WEST SUSSEX COUNTY COUNCIL CONSULTATION

TO:	Arun District Council FAO: Simon Davis
FROM:	WSCC Highway Authority - Matthew Bartle
DATE:	18 March 2019
LOCATION:	Cinders Lane Nursery & works to R/O Cinders Lane Yapton BN18 0JJ
SUBJECT:	Y/4/19/RES Approval of reserved matters following outline consent Y/5/17/OUT for 51 No. dwellings. This application affects a Public Right of Way.
RECOMMENDATION:	More information

SITE LAYOUT | SERVICES PLAN (1 of 1)
DEVELOPMENT AT:
CINDERS LANE
YAPTON
BN18 0JJ
FOR
CRAYFERN HOMES LIMITED
Scale :1:300 @ A1 Date : June 2019
Drawing No : 19.14.107

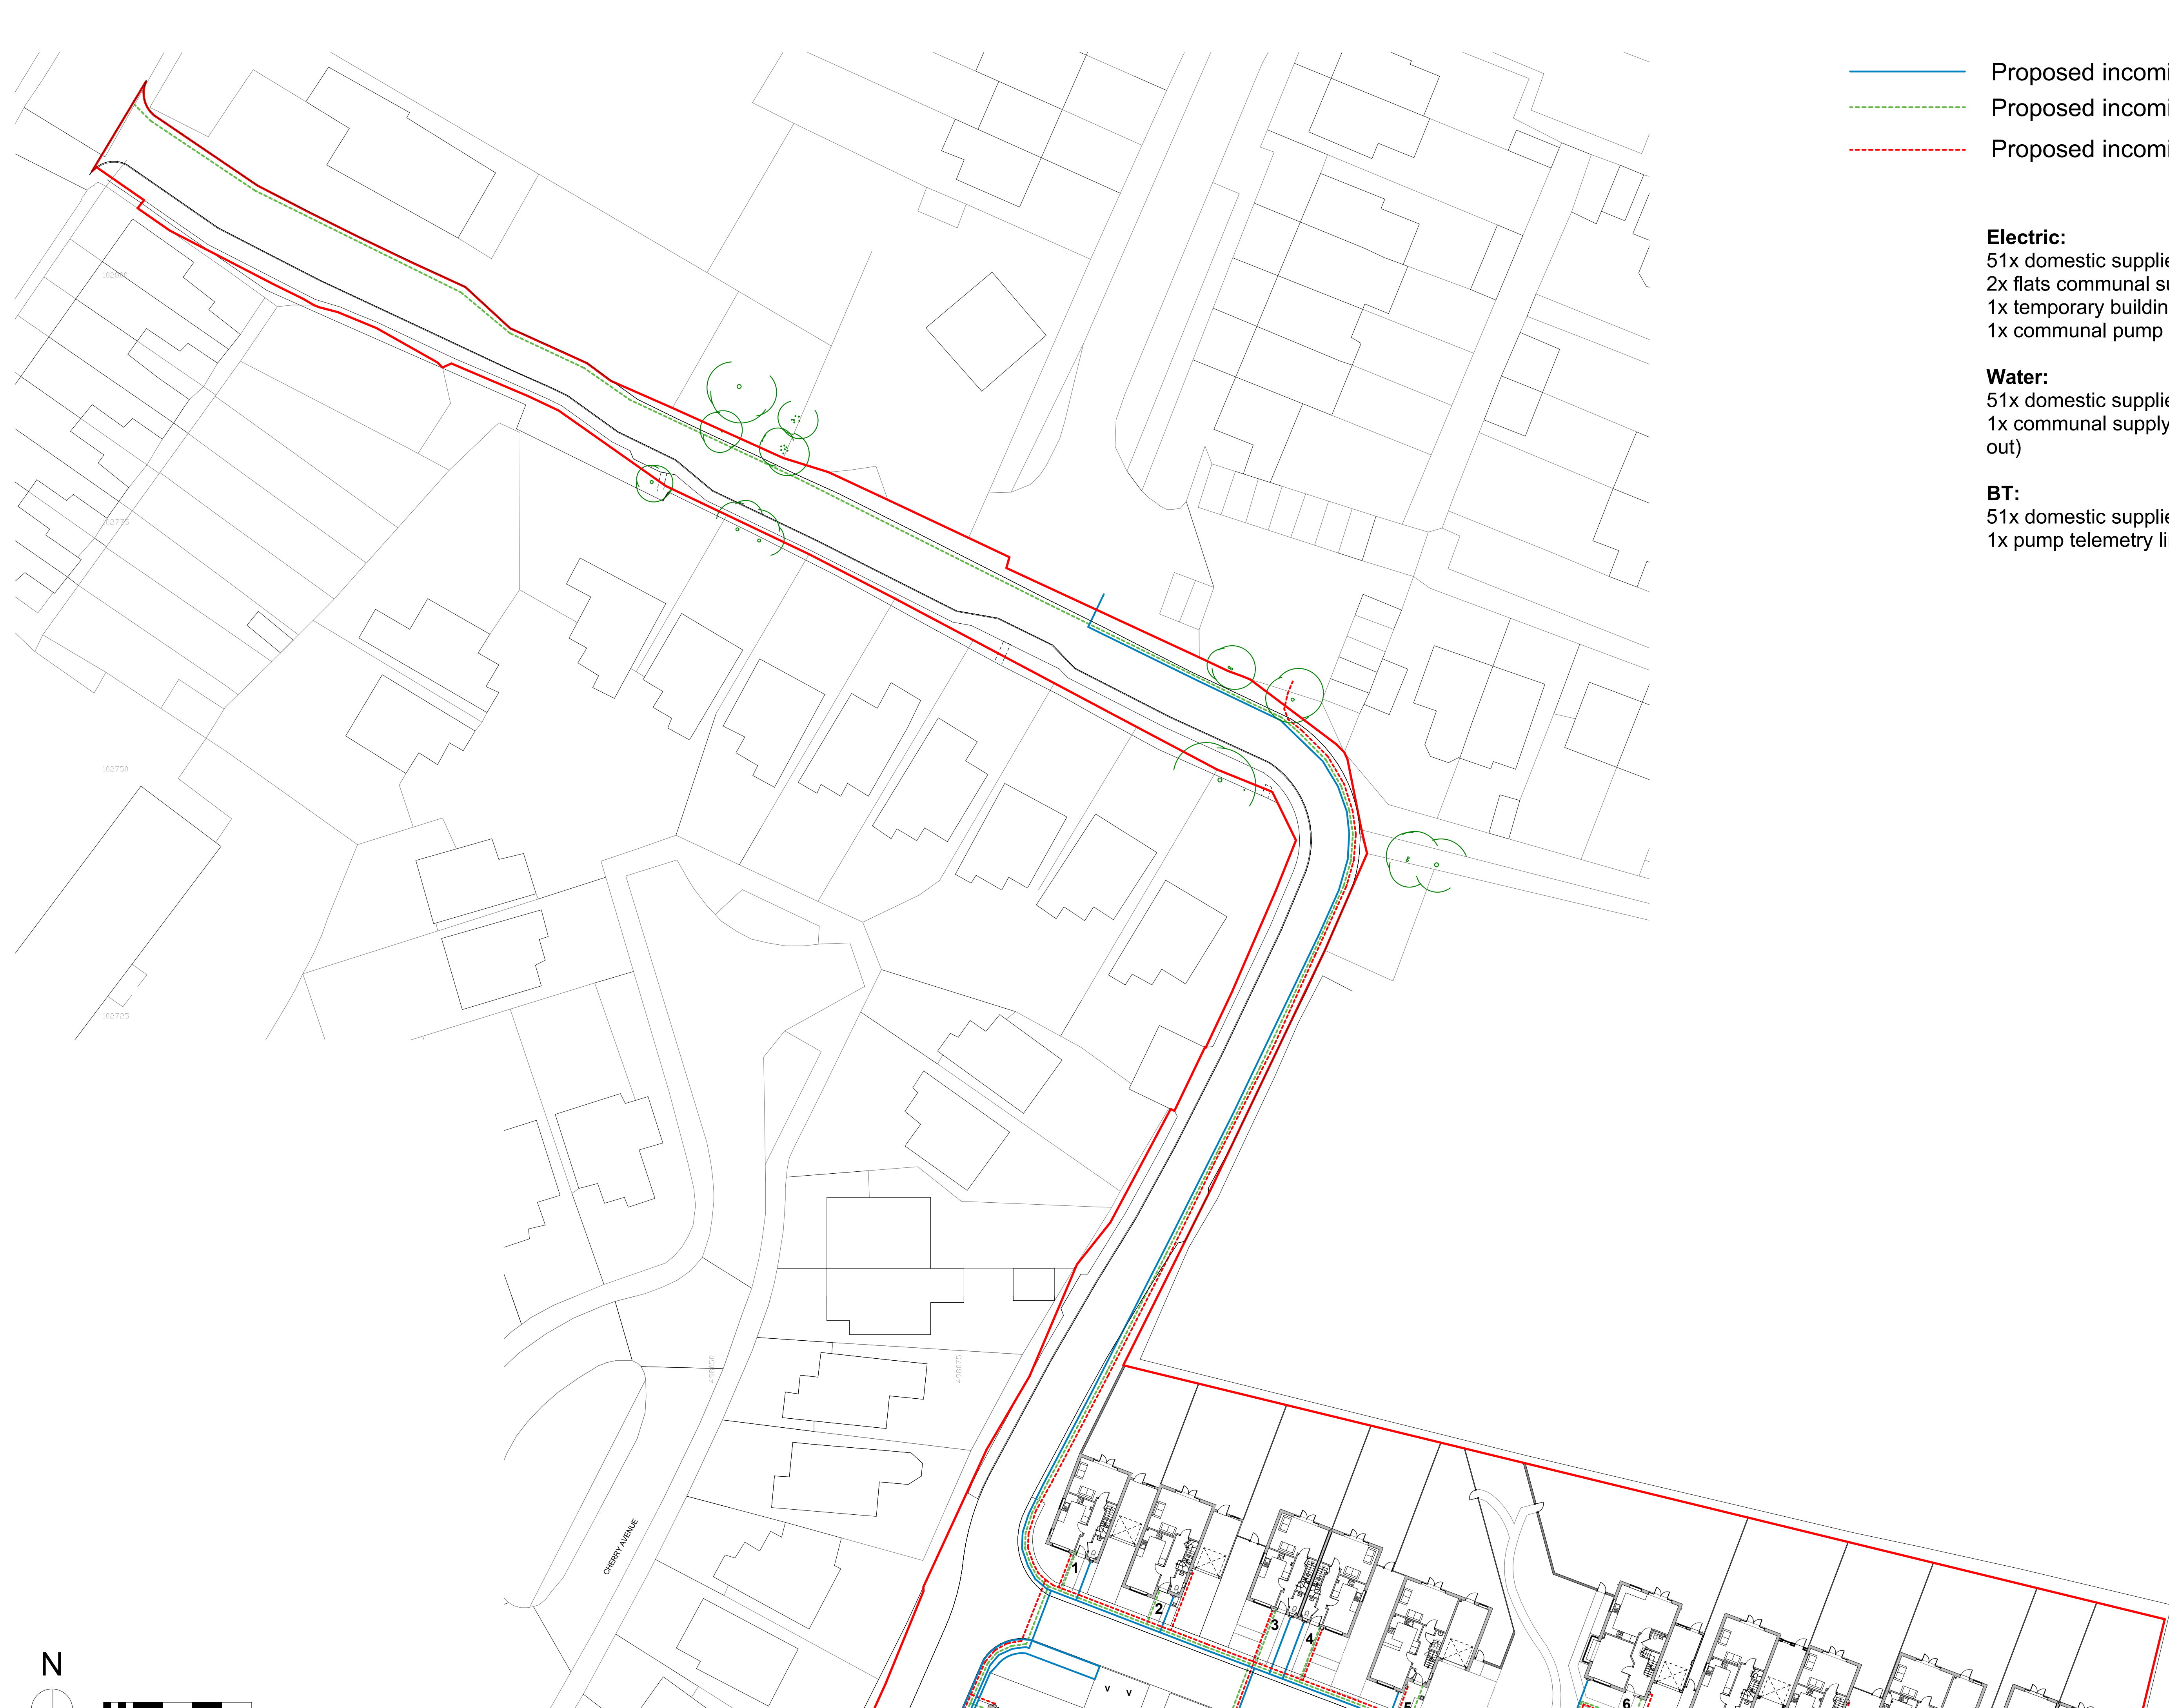
Would the applicant please confirm how statutory undertakers' services are to be accommodated within the layout?
